**COLORADO**  
Department of Transportation

May 8, 2019

RE: Appaloosa - SH24 Sub Lot 2 - PPR\_EA18246 Revised 05/08/10

**APPALOOSA HIGHWAY 24 SUBDIVISION
FILING NO. 1A
COLORADO SPRINGS, COLORADO
GRADING AND DRAINAGE PLAN**

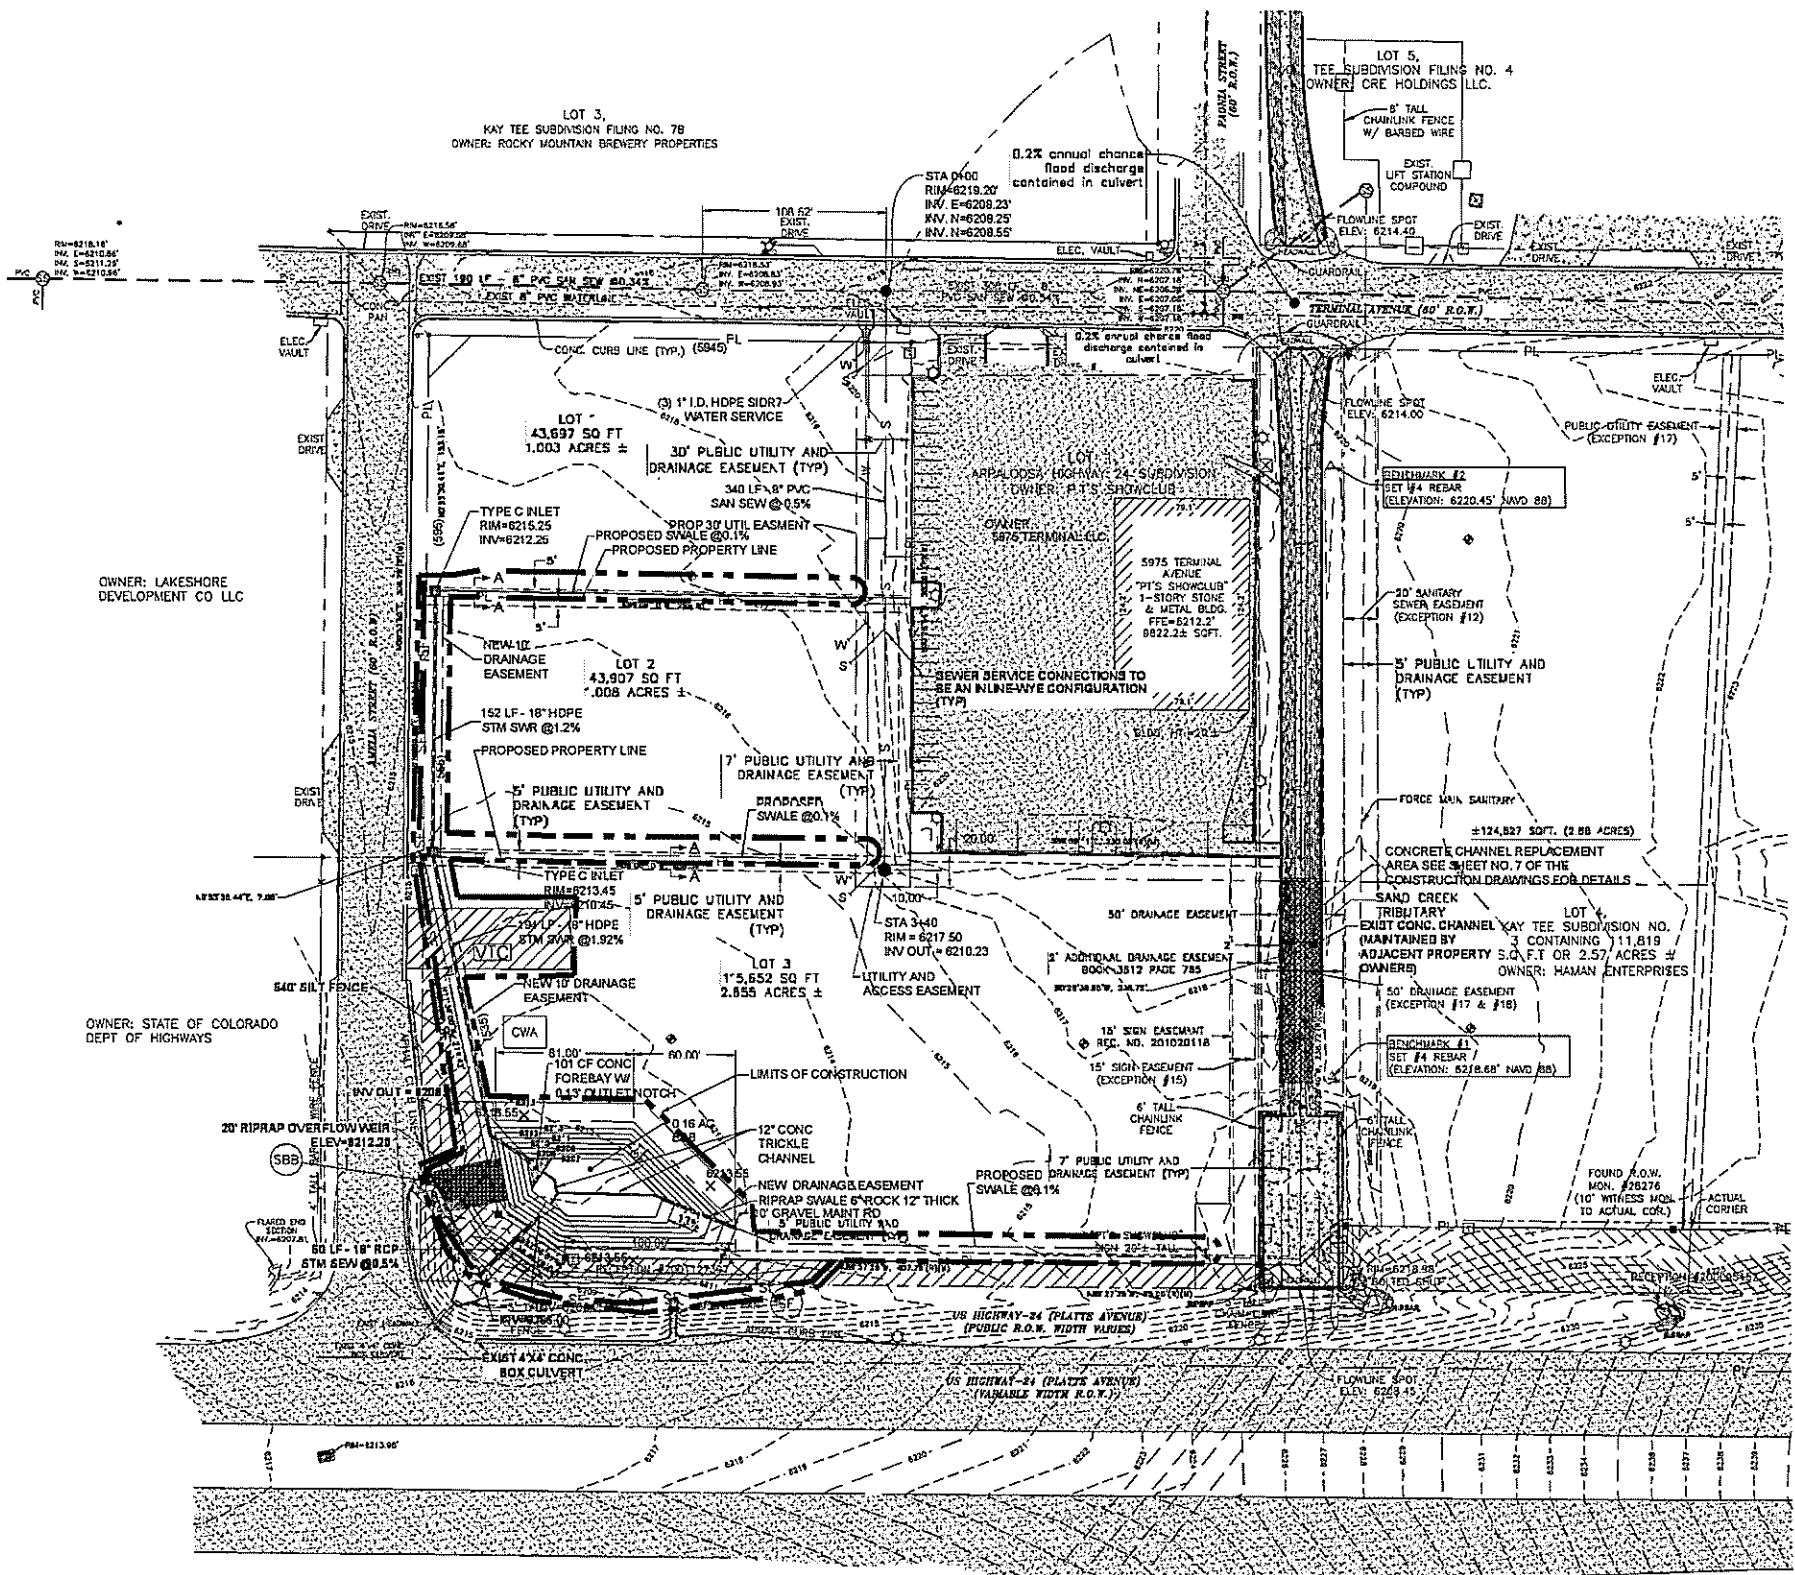
- a. The development is following the water quality and detention requirements set forth by the Colorado Springs Drainage Criteria Manual.
- b. They are also replacing a portion of a concrete channel that looks to be failing within a Zone AE floodplain along the eastern edge of the property. I'm assuming they are working with the City's floodplain manager on this portion of the project. There is no hydraulic information for this channel within the report, but they are simply replacing the channel in kind. These improvements shouldn't change the hydraulics for the culvert under SH 24.
- c. Please provide riprap from the site outlet all the way to the existing CDOT culvert apron.
